# **GATWICK AIRPORT NORTHERN RUNWAY PROJECT**

Planning Inspectorate's Reference: TR020005

### **COMMENTS ON THE APPLICANT'S RESPONSES TO ExQ2**

**Deadline 8: WEDNESDAY 07 AUGUST 2024**

Temporary Diversion 346_2Sy

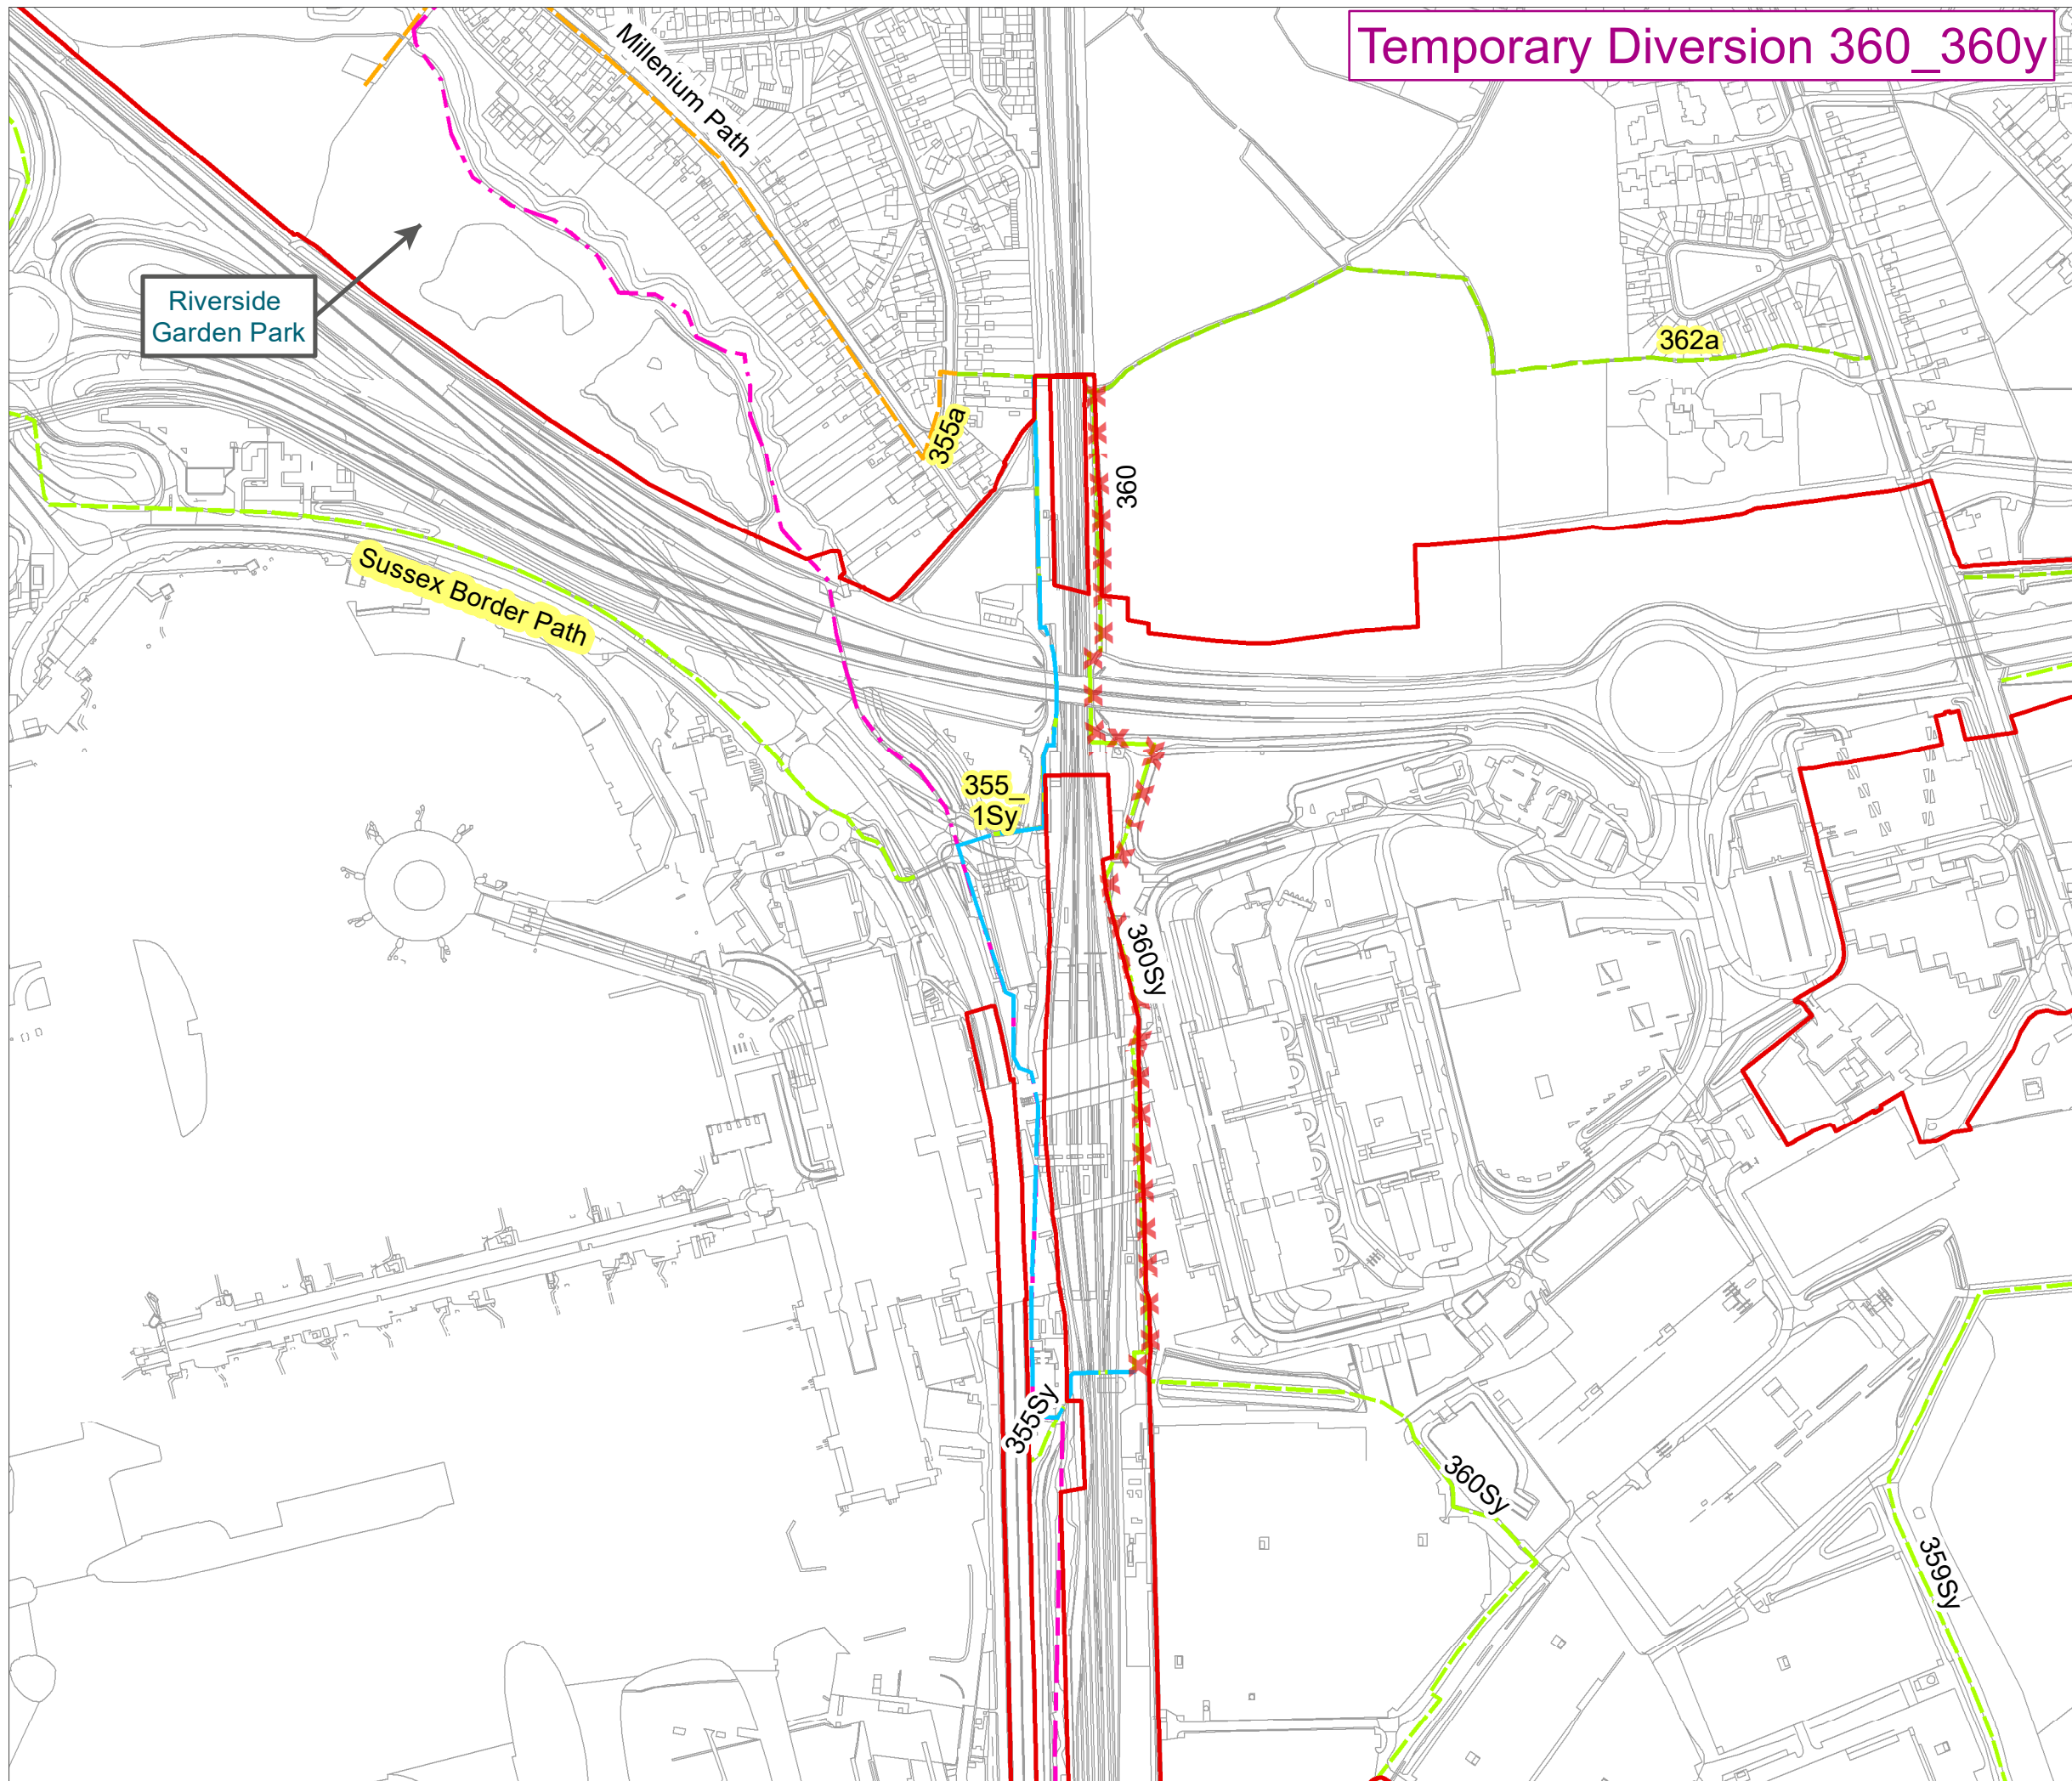
<b>Land use and Recreation</b>			
LU.2.2	Applicant	<p><b>Public Rights of Way Management Strategy</b> In respect of Table 4.1.1 of the Public Rights of Way Management Strategy <a href="#">[REP2-009]</a>, please confirm how long West Sussex 346_2Sy is to be temporarily closed/ diverted?</p> <p>See link to the Applicant's Answer: <a href="#">[REP7-086]</a></p>	<p>On a high-level basis, the Authorities would comment that:</p> <ul style="list-style-type: none"> <li>Any alternative route must be suitable for lawful users of the route; and</li> <li>Any alternative route is the landowner/contractors responsibility to suitably sign and maintain for the whole duration of use.</li> </ul>
